ENTECH
ENGINEERING, INC.

Re: Response to Colorado Geological Survey Review
Soil, Geology, & Geology Hazard Study
Sterling Ranch East – Preliminary Plan No. 1
Parcel Nos. 17, 18, 22, 23, 24, 26, 37, & 38
El Paso County, Colorado
Entech Job No. 220571

CGS COMMENTS AND ENTECH ENGINEERING, INC. RESPONSES

2 OF 36

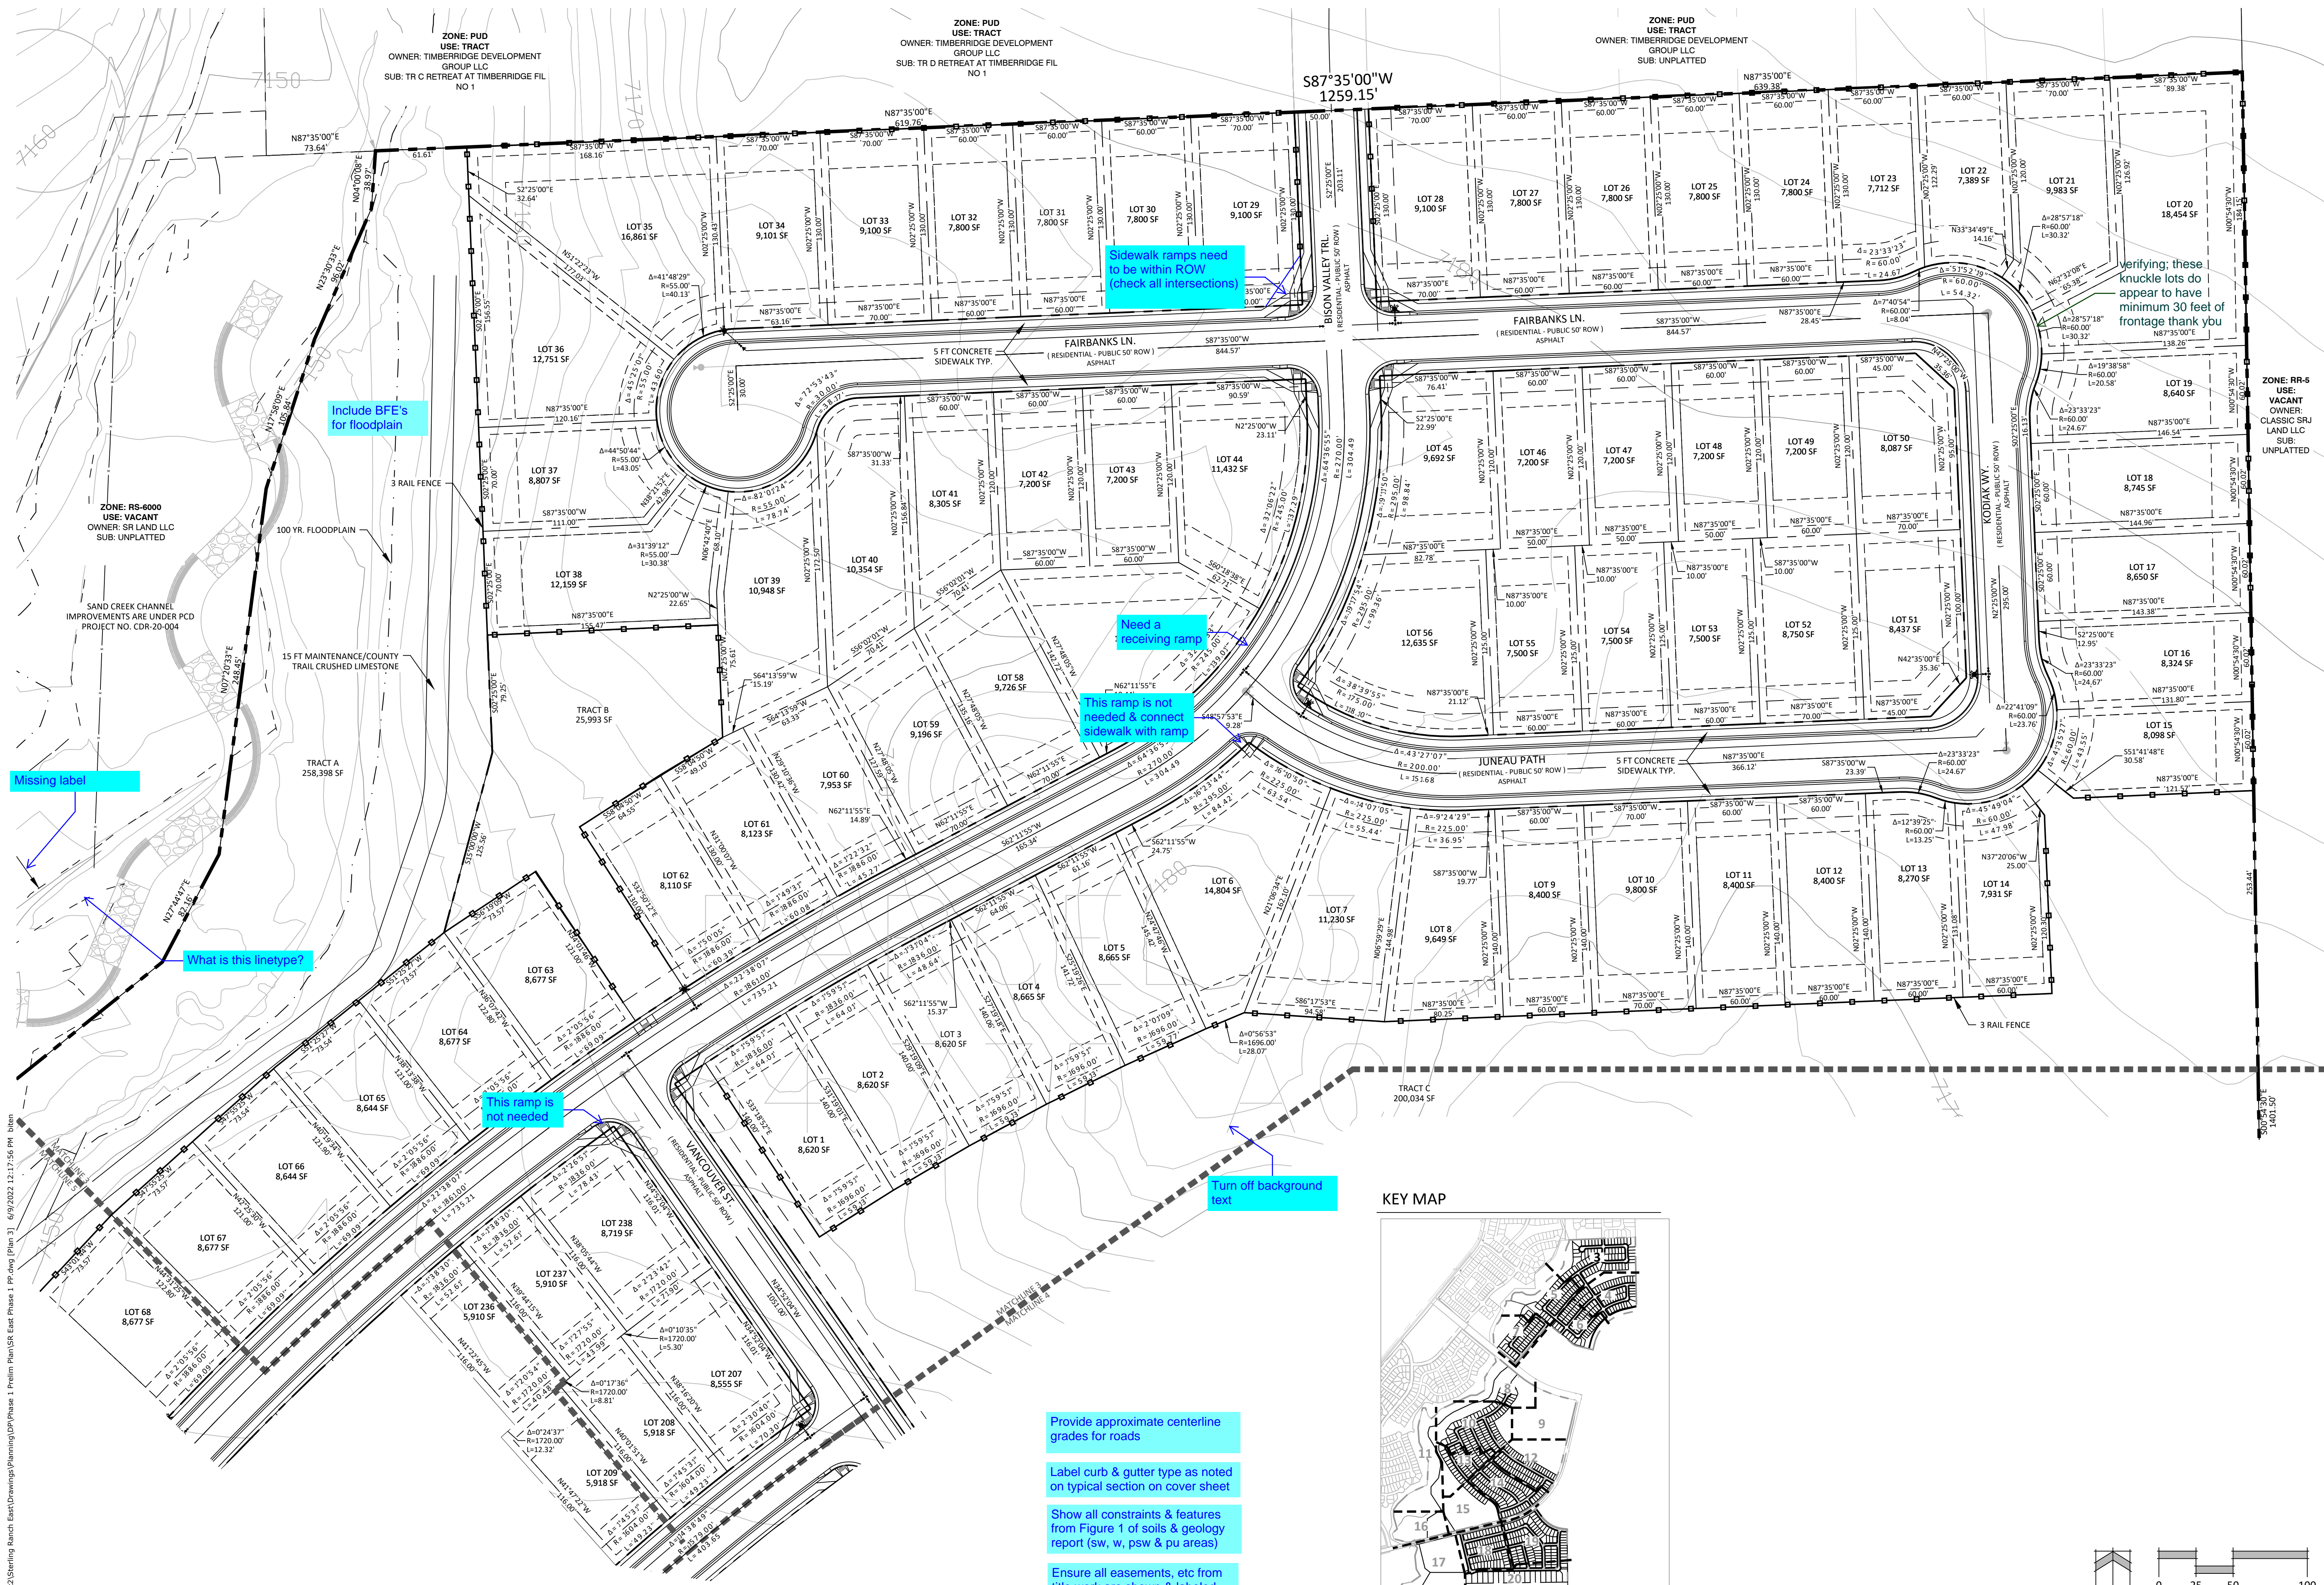
1. Sheet 1 of the preliminary plan shows Filing 3 to the north of Sterling Ranch Rd. and north of Briargate Pkwy. Our review of the grading plans indicates that the parcel north of Sterling Ranch Rd. is Filing 1.
